Integra 61 - Phase 7 - Non-material Amendment to DM/22/01168/RM

We write on behalf of our client, GMI Construction, in relation to an application for a non-material amendment pursuant to reserved matters permission DM/22/01168/RM relative to Plot DC5 (Phase 7) of planning permission DM/18/01597/VOC. Permission DM/18/01597/VOC relates to Integra 61, land south of Bowburn and west of the A688.

The application proposes a non-material amendment to Condition 1 of the planning permission regarding adherence with the approved plans as set out in Part 3 of the decision notice.

7069-10 - B
 PLANNING

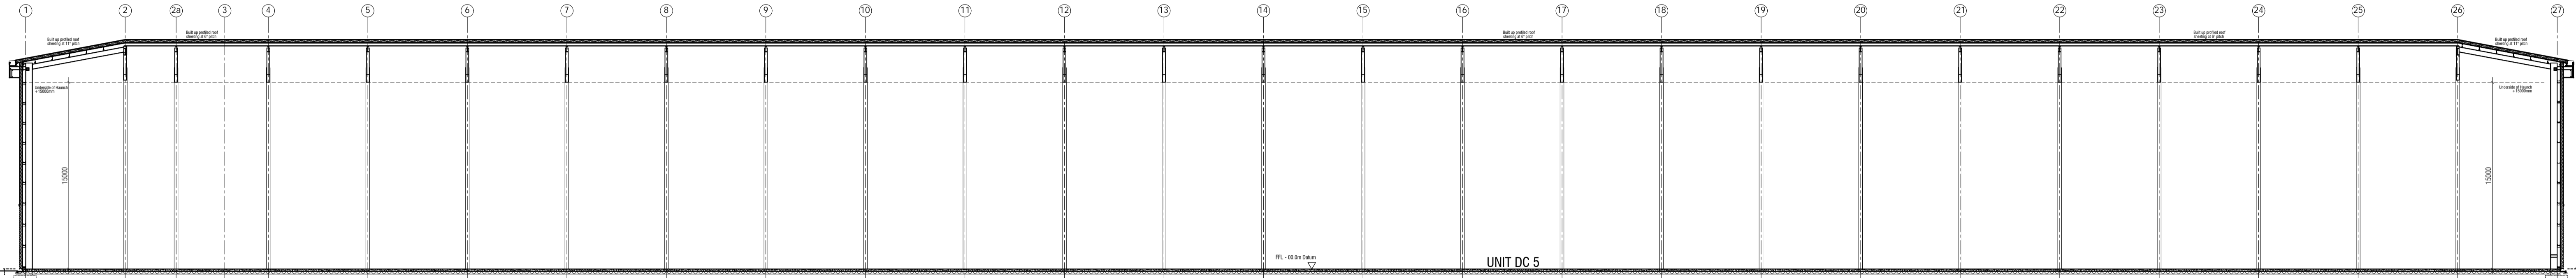
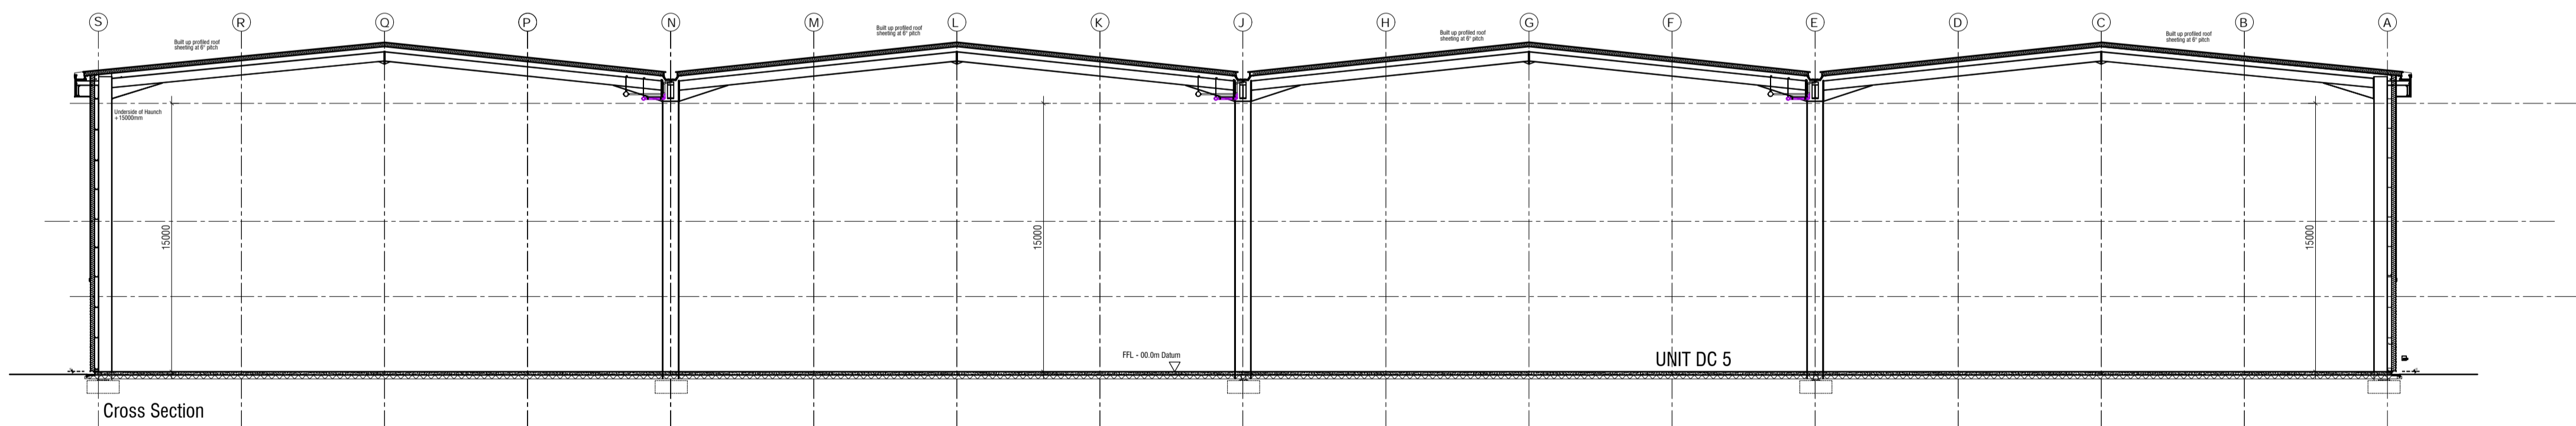
Plan	Old Drawing No.	New Drawing No.	Changes
DC5 Proposed Site Plan	5725.DC5_PP.1.5	7069-005-G	Updated to show Georoc retaining walls Car park layout and site pedestrian access updated.
Proposed Building Plans	7069-09-A	7069-09-B	Fire exit door locations updated to suit steel frame
Proposed Building Sections	7069-10-A	7069-10-B	Roof profile updated.
Proposed Building Elevations	7069-11-A	7069-11-B	Building eaves detail updated from horizontal cladding to vertical cladding Additional door added to front elevation (southwest) Personal and level access door colours updated to bring in lines with the notes on the material schedule Personal door locations updated to coordinate with steel frame
Proposed Admin Office Sections	7069-12-A	7069-12-C	Canopy above reception area added
Proposed DC Office Sections	7069-13-A	7069-13-C	Updated hub office roof
Proposed Roof Plans	7069-14-A	7069-14-C	Warehouse roof slope updated Hub office roof slope updated

7069 - 15 - B
 Planning

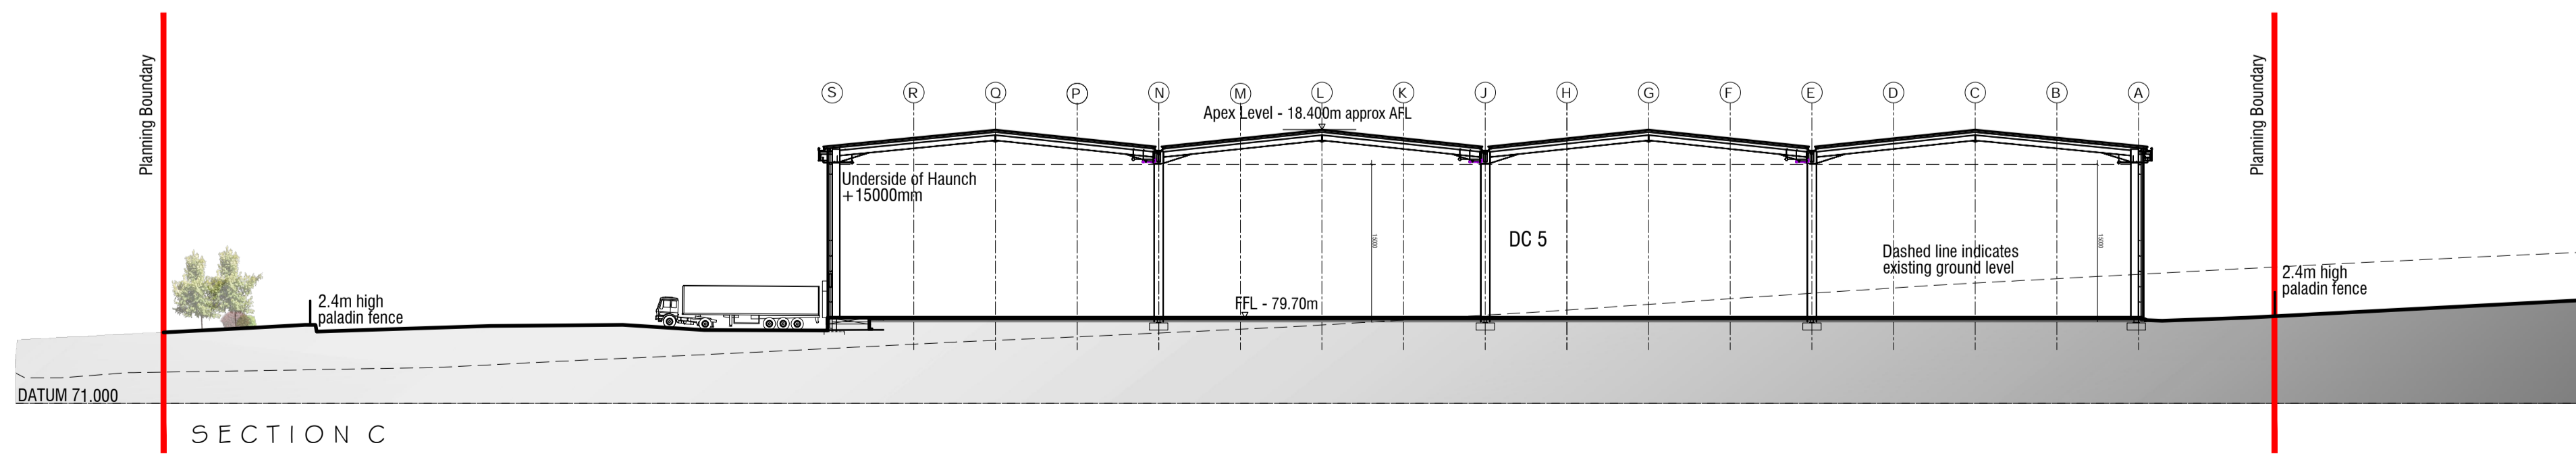
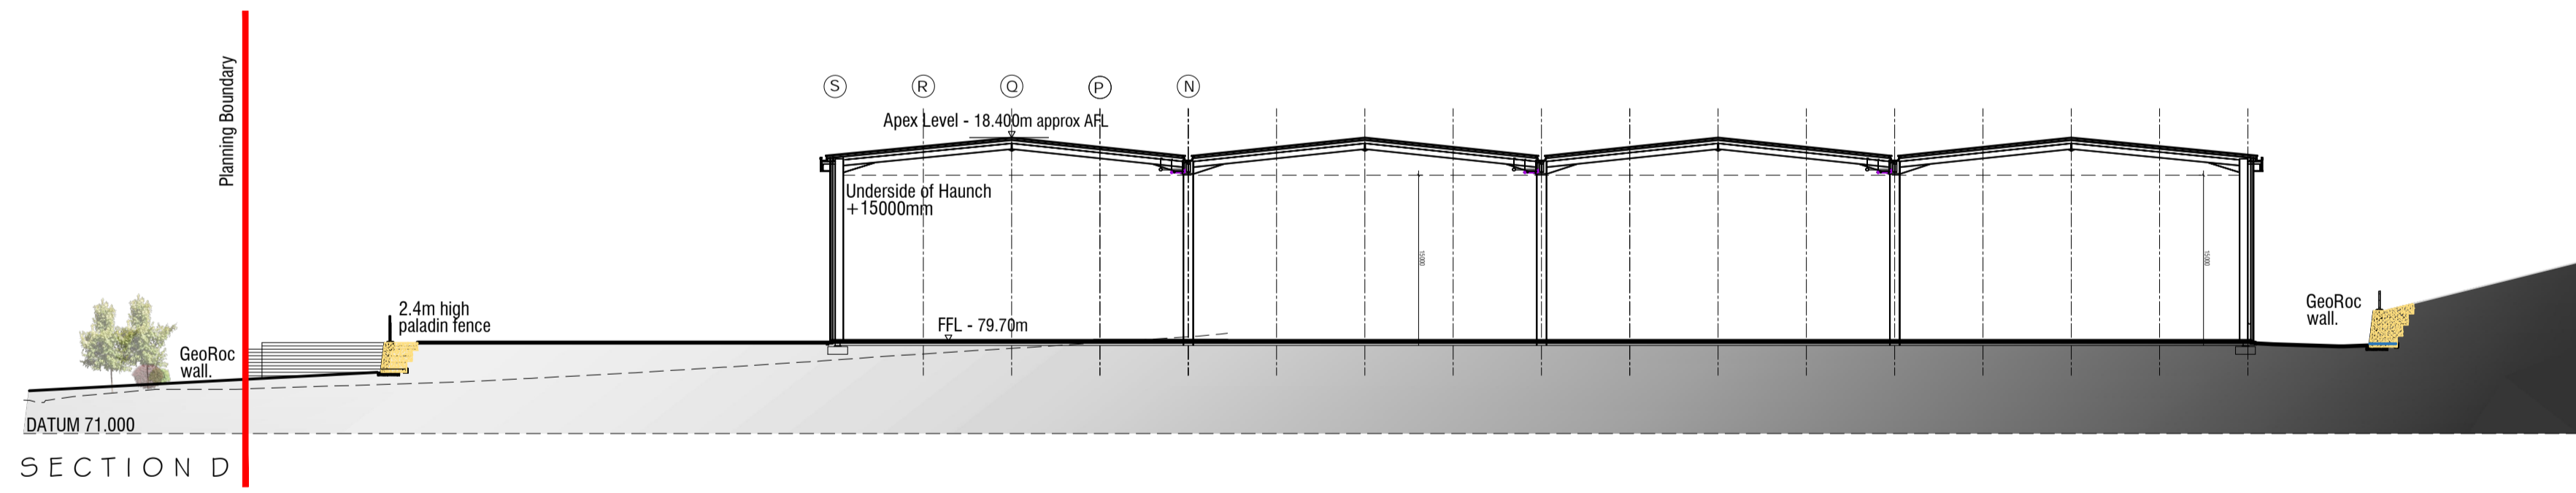
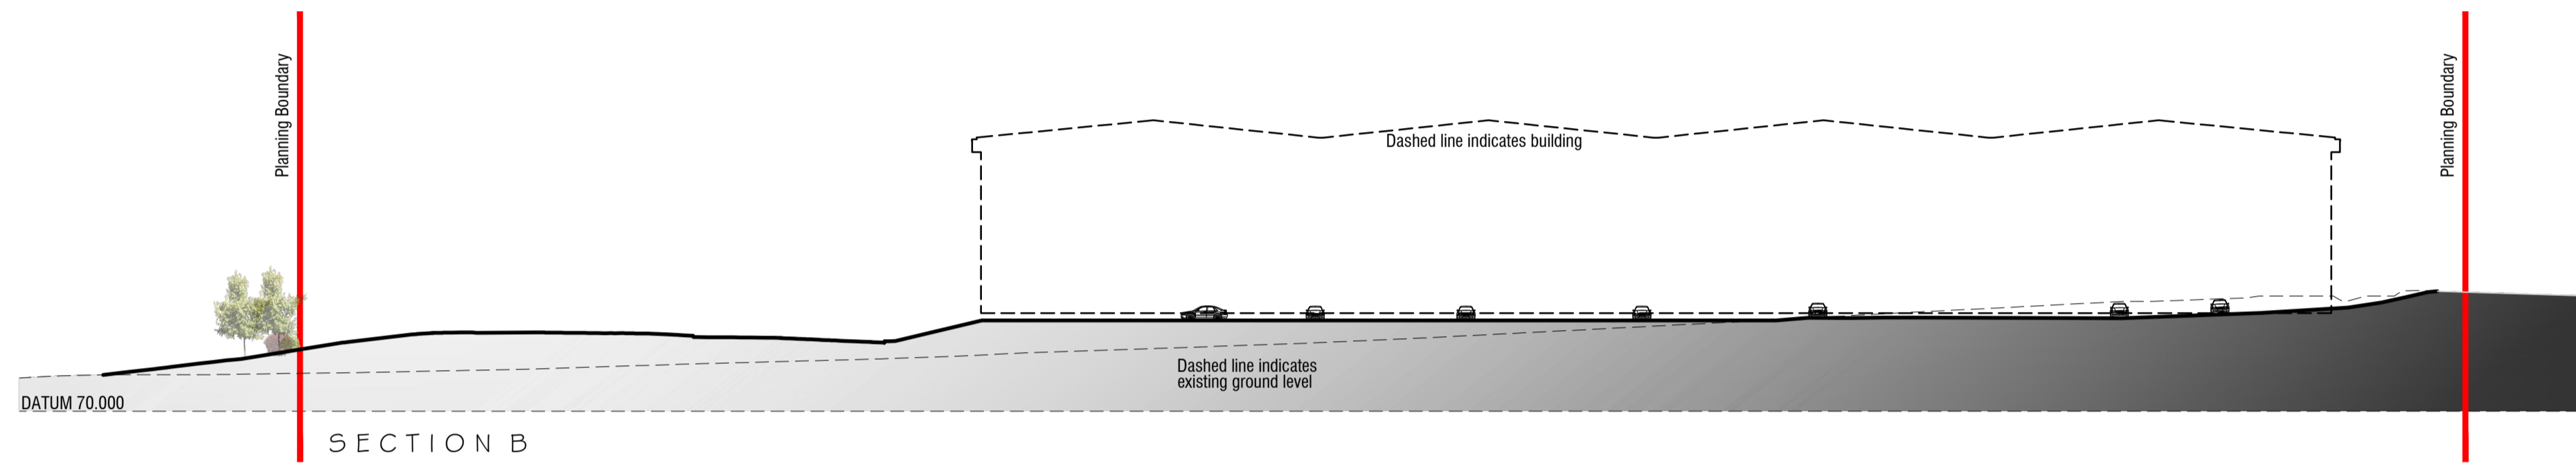
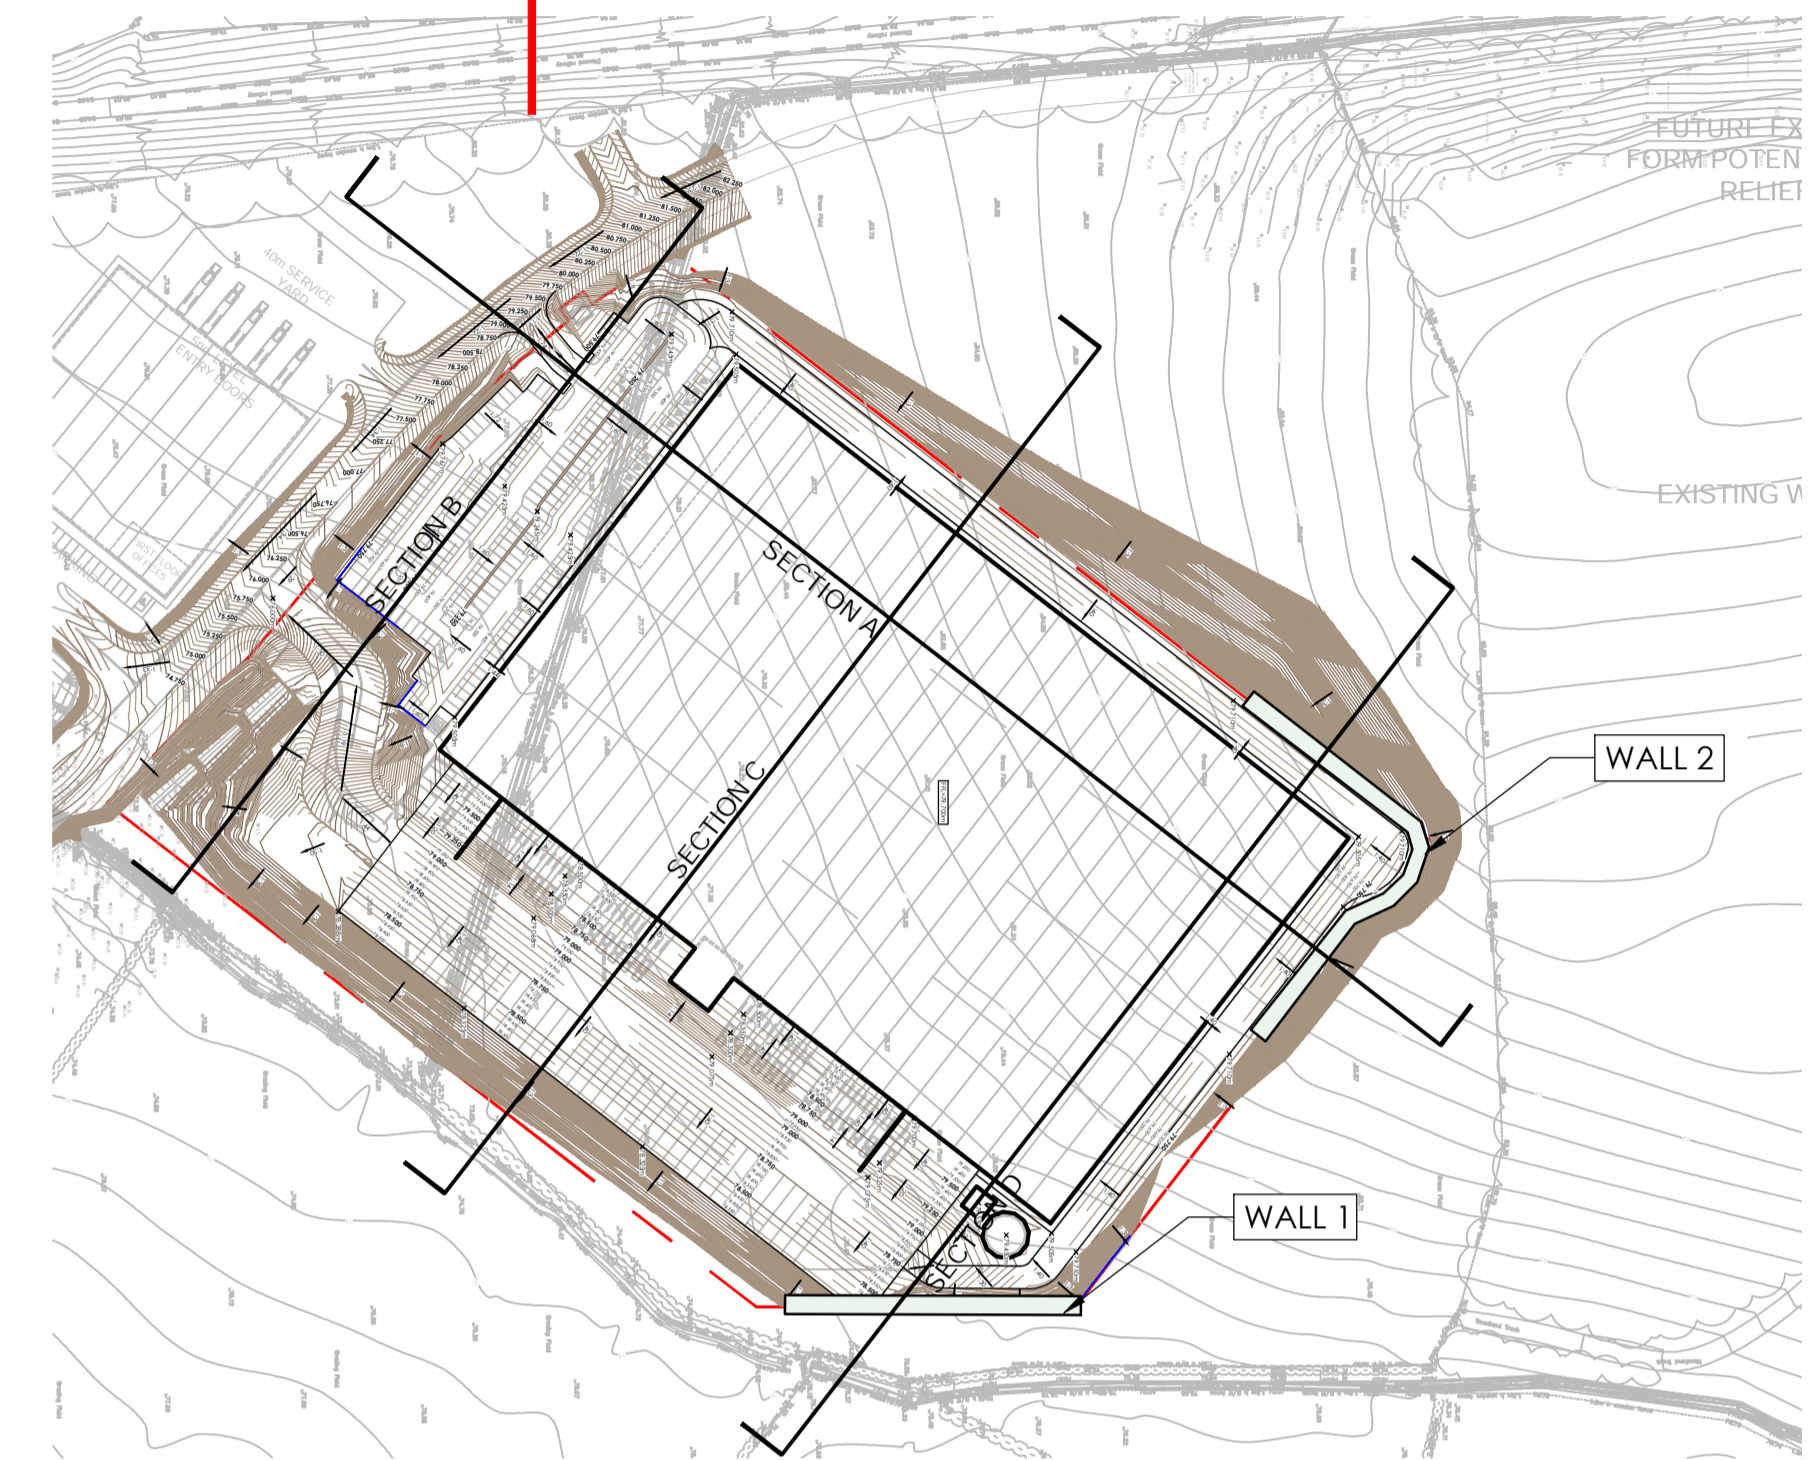
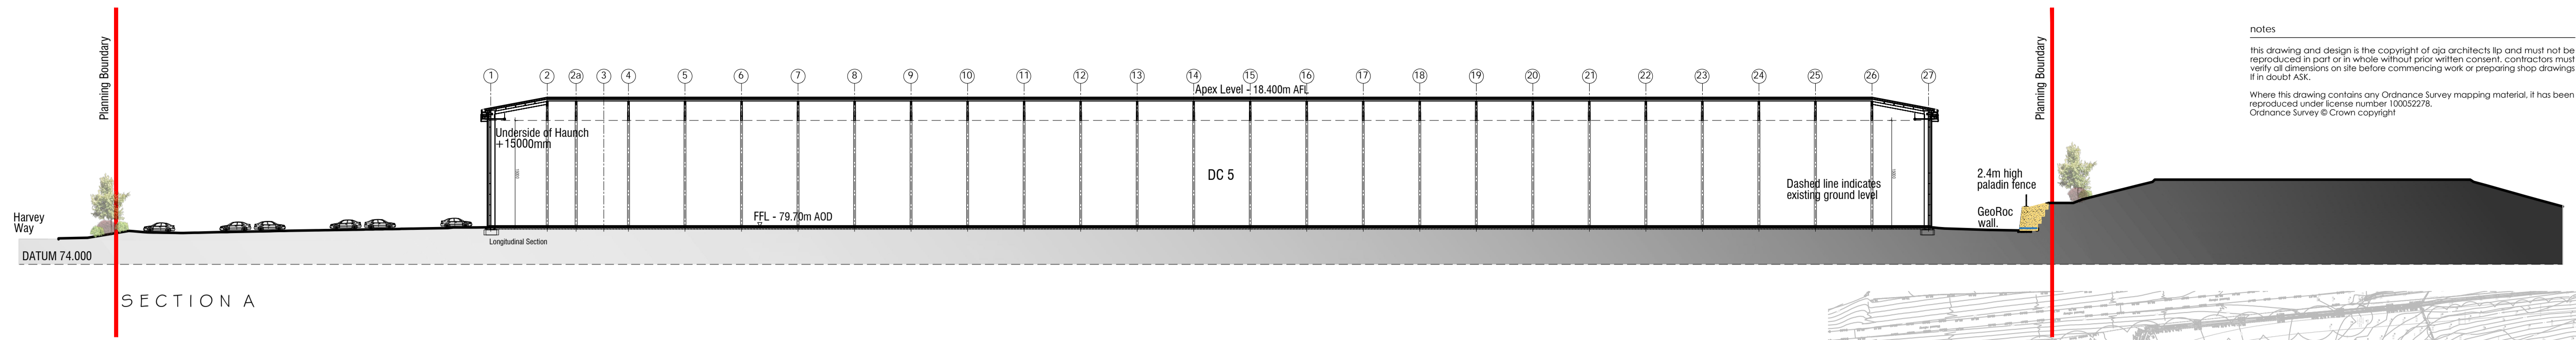
Proposed Site Sections	7069-15-A	7069-15-B	Site levels updated Warehouse F. F. L updated Retaining walls added to drawing
Hard Surface Plan	5725.DC5_HSP.2.0	5725.DC5_HSP.2.OA	Car park layout updated including pedestrian access point Extent of service yard updated local to Georoc retaining wall Width of fire track increased including the corner of fire track extended local to Georoc retaining wall Colour of tarmac footpath updated to black
Planting Plan Overview	5725.DC5_PP.1.0	5725.DC5_CON_PP.1.OA	Updated landscape drawings to capture the general site plan updates
Planting Plan 1 of 5	5725.DC5_PP.1.1	5725.DC5_CON_PP.1.1A	Updated to capture the general site plan updates
Planting Plan 2 of 5	5725.DC5_PP.1.2	5725.DC5_CON_PP.1.2A	Updated to capture the general site plan updates
Planting Plan 3 of 5	5725.DC5_PP.1.3	5725.DC5_CON_PP.1.3A	Updated to capture the general site plan updates
Planting Plan 4 of 5	5725.DC3_PP.1.4	5725.DC5_CON_PP.1.4A	Updated to capture the general site plan updates
